Reference: 0772105

Re: 2-6 Hassall Street, Parramatta – Response to Submissions

I refer to the Site at 2-6 Hassall Street, Parramatta and the Submissions received from City of Parramatta Council (Council) and Transport for New South Wales (TfNSW), regarding the State Significant Development 9670 for the Western Sydney University Innovation Hub (Proposal).

2 MATERIALS & FINISHES AND FURNITURE PLAN - PD HASSALL STREET  
1:200

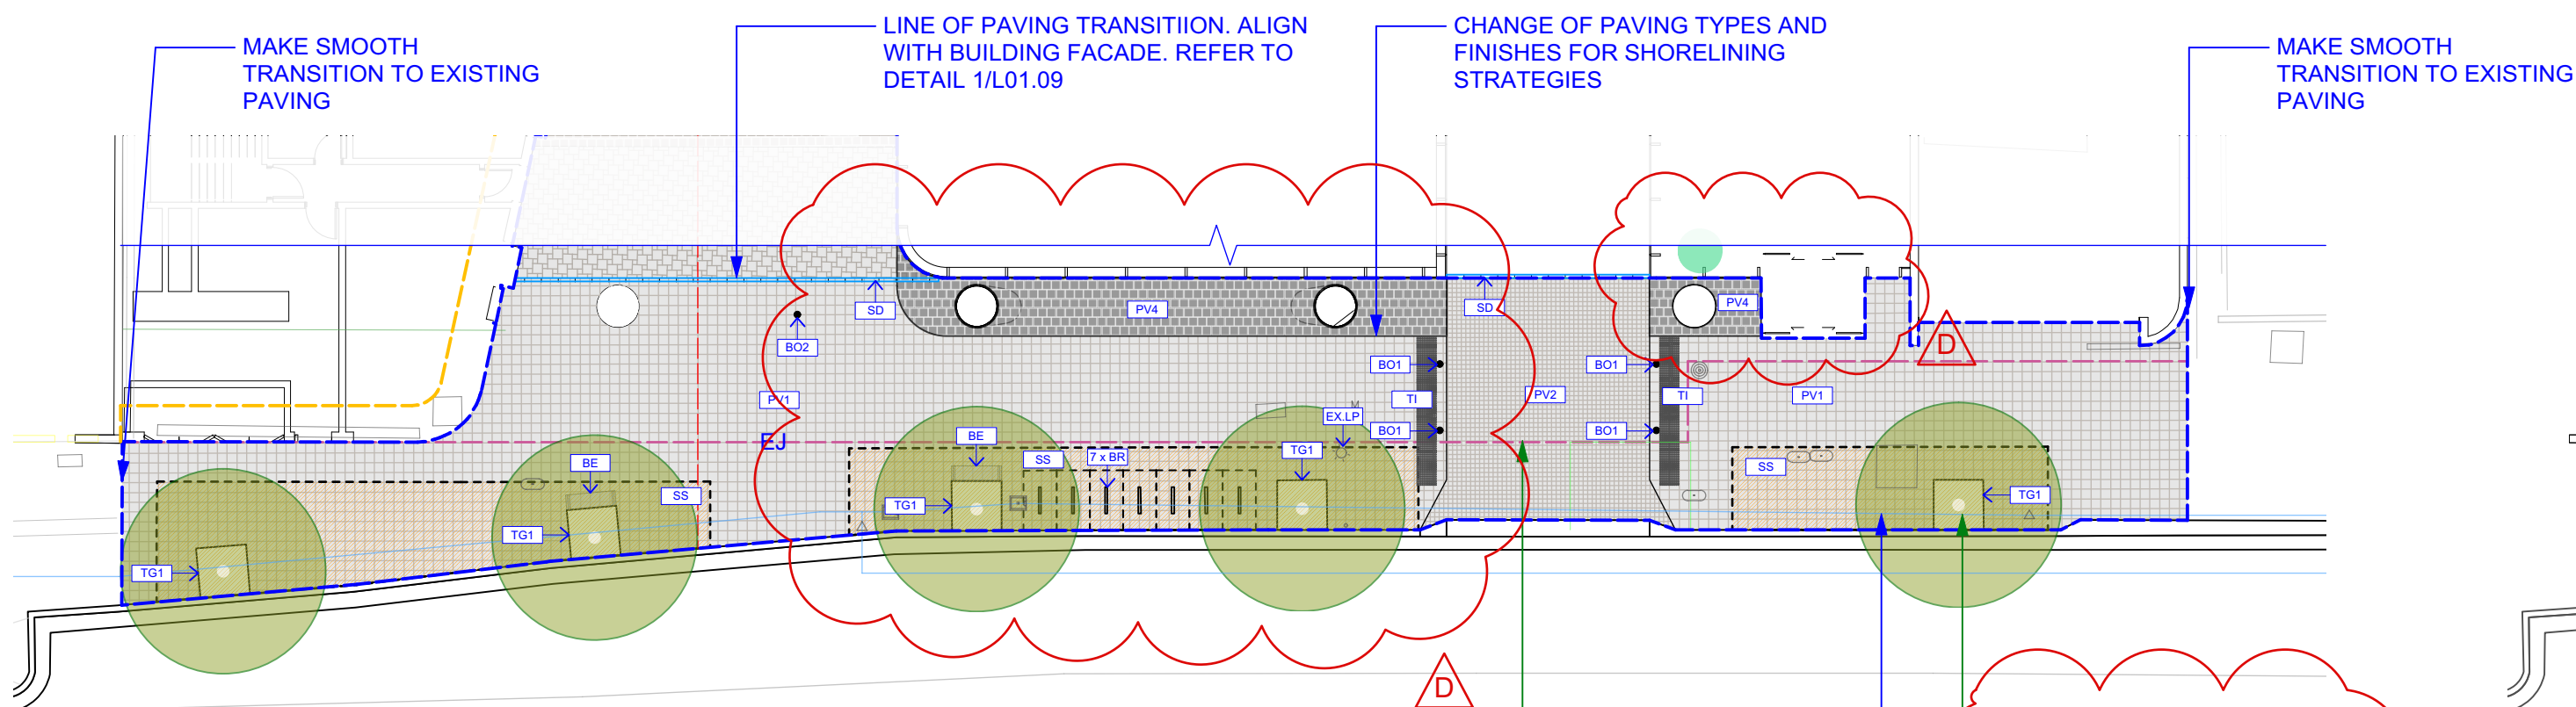
The bollards shown at the driveway crossover of Hassall street footpath are not recommended. These should be replaced with warning TGSIs.

These bollards have been provided to ensure the required sight splays are achieved for appropriate driver visibility of pedestrians walking across the driveway, in compliance with Figure 3.3 of AS2890.1. It is necessary to ensure that pedestrians do not occupy this area, therefore it is deemed appropriate to provide a physical barrier in this location to prioritise pedestrian safety.

Sheet Name
BASEMENT
©BLIGHT RAYNER ARCHITECTURE PTY LTD ACN 614335956
Use figured dimensions only. Do not scale. Check all dimensions on site prior to fabrication or setout. These designs, drawings and specifications are copyright and must not be used, kept or copied by any means without permission.

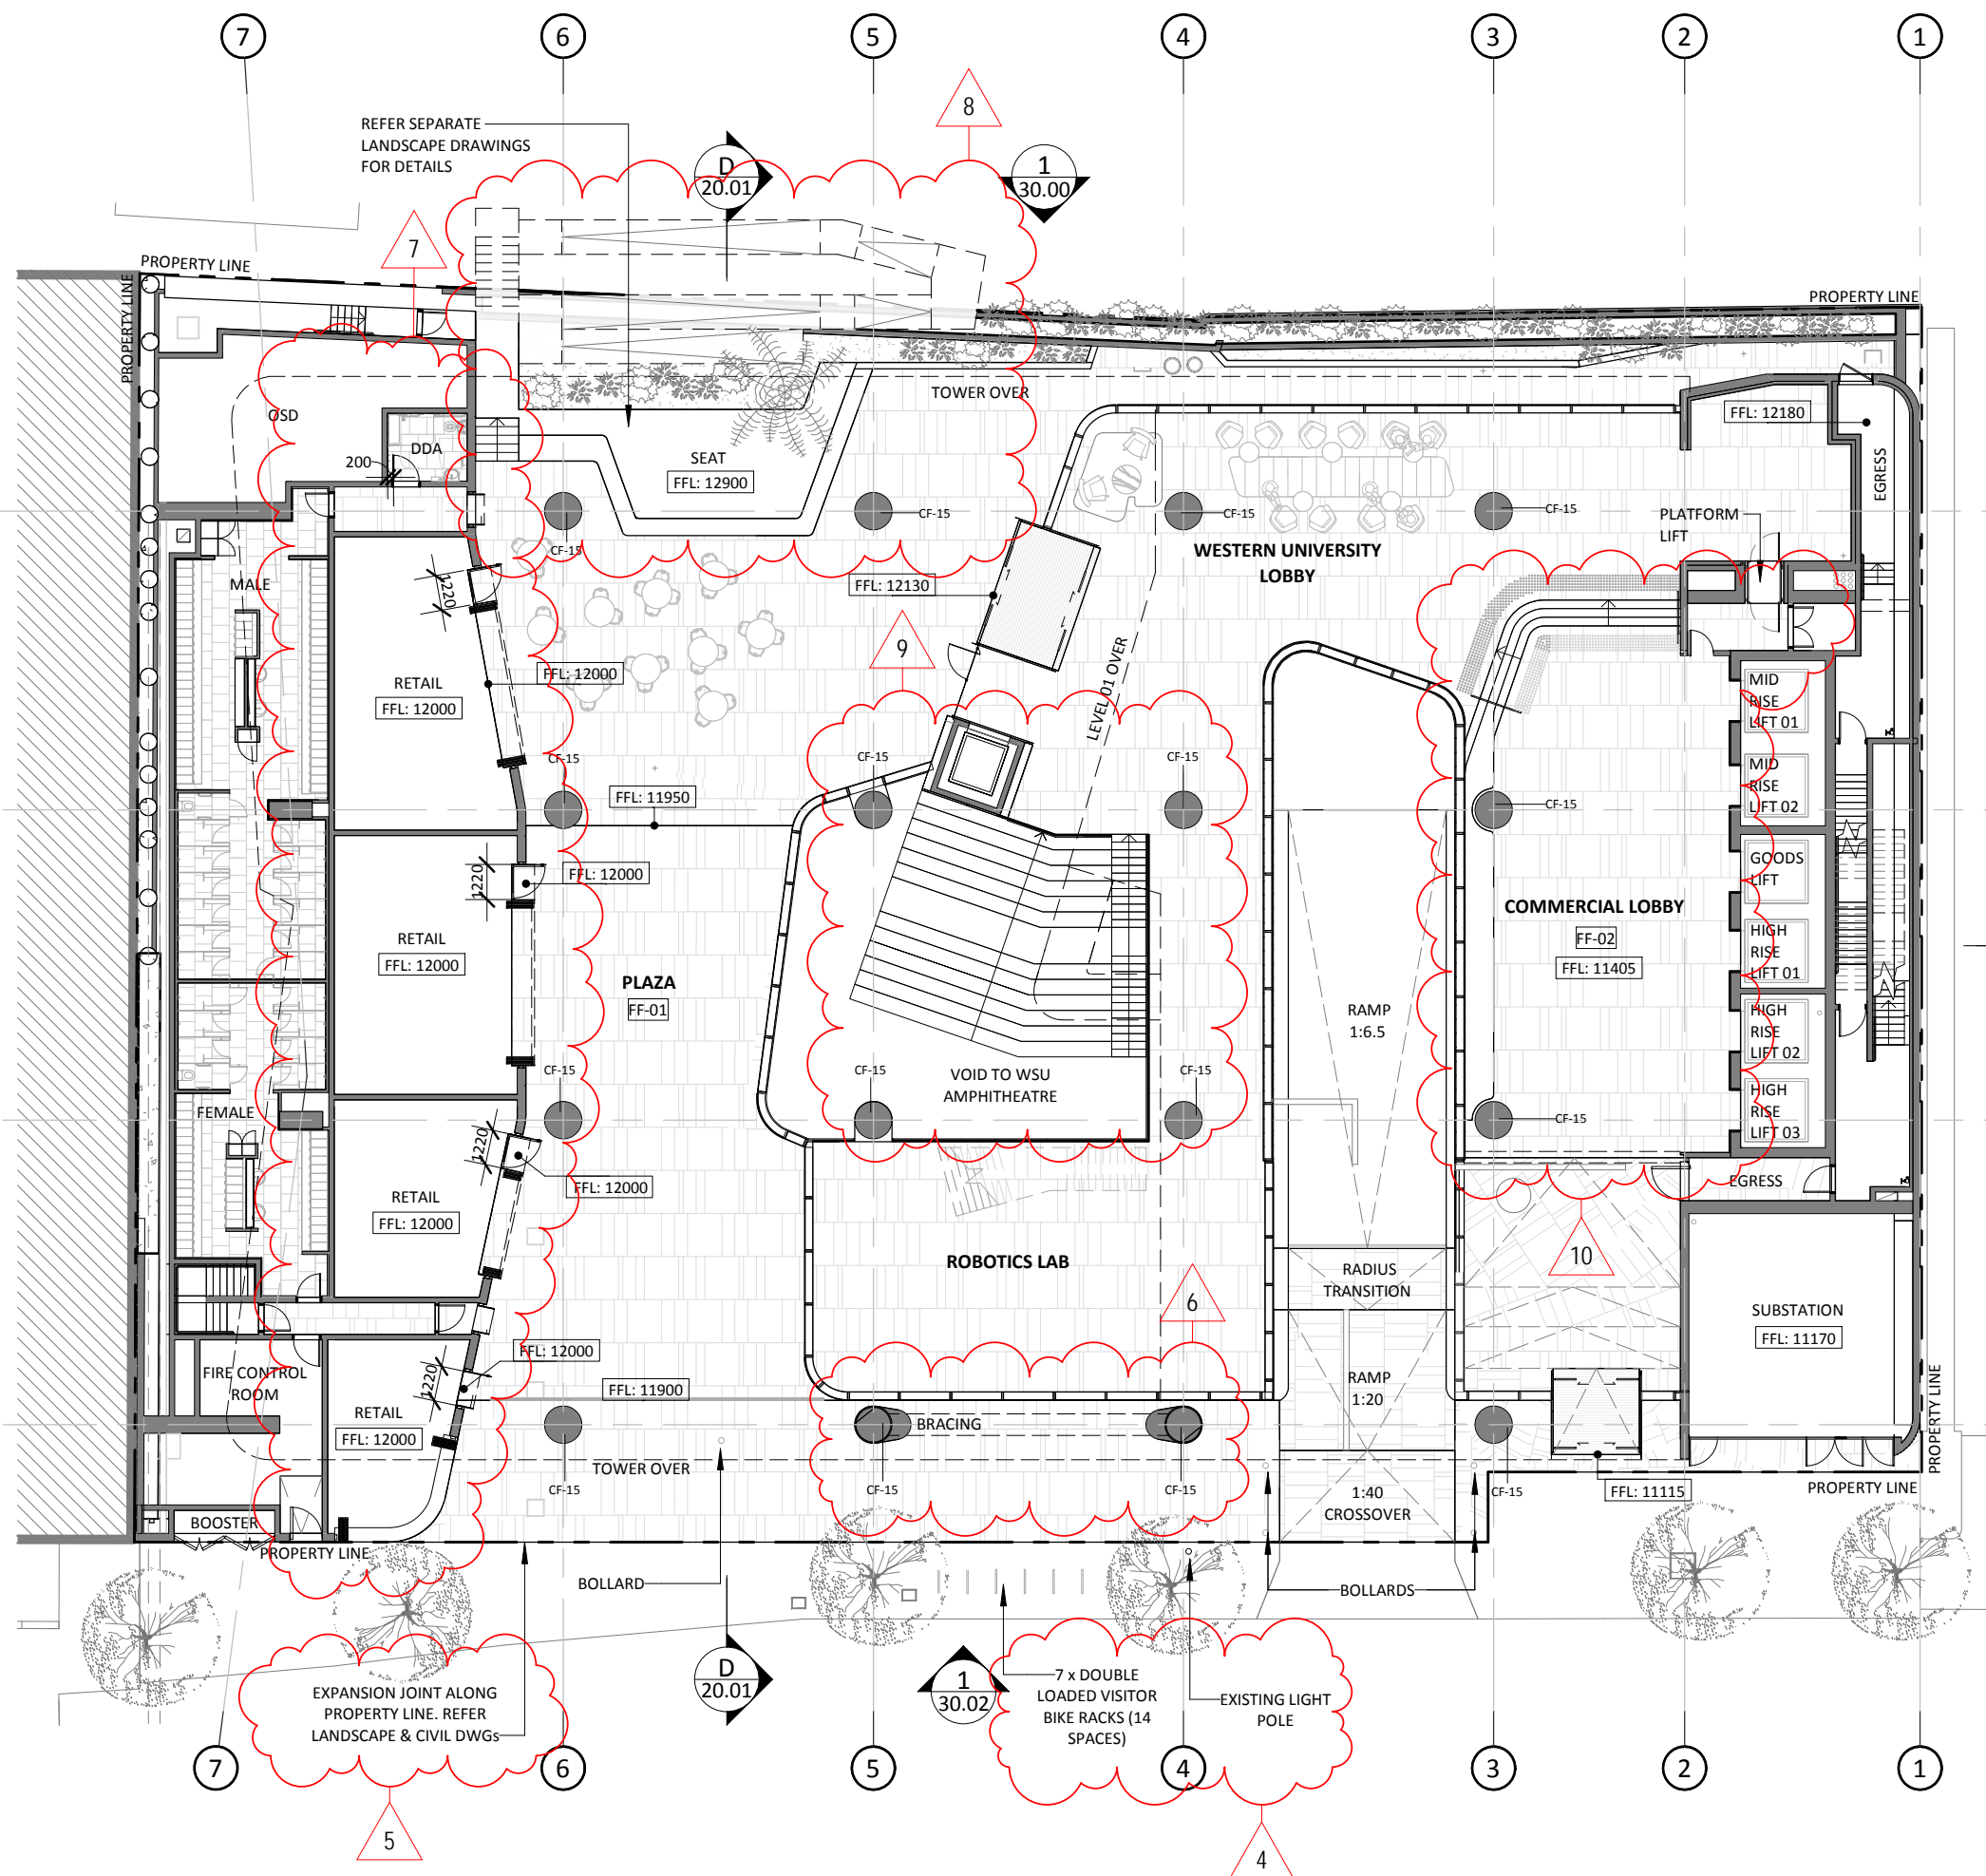
Must ensure that adequate sight distance in accordance with AS2890.1-2004 is achieved at the basement entry driveway.

Noting that Hassall Street is a one-way street in a westbound direction, adequate sight distances can be achieved at the basement entry, in accordance with AS2890.1. This would be confirmed at Construction Certificate stage of development and is expected to form a Condition of Consent.
